Application No: FP/230/21/HH
Site Address: Spring Cottage 90 Felpham Road Felpham PO22 7PD
Description of works: Partial conversion of existing garage. (This application may affect the character and appearance of the Felpham Conservation Area)

Thank you for your internet representation made on 14th November 2021 which has been recorded as no objection with the comments as follows:

East Elevation

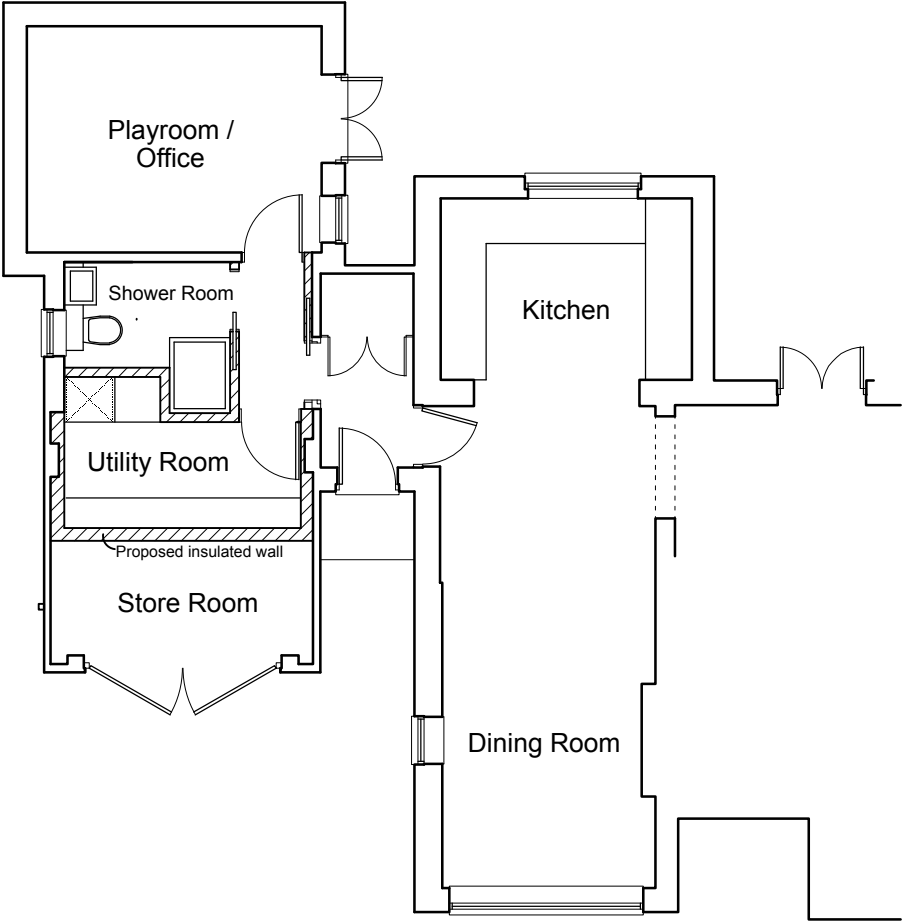
The only external alterations appear to be the replacement of the garage doors with two new timber doors serving a storage area.

The proposed new doors are of good design and subject to them being painted or stained an appropriate colour there will be no harm to the character or appearance of the conservation area.
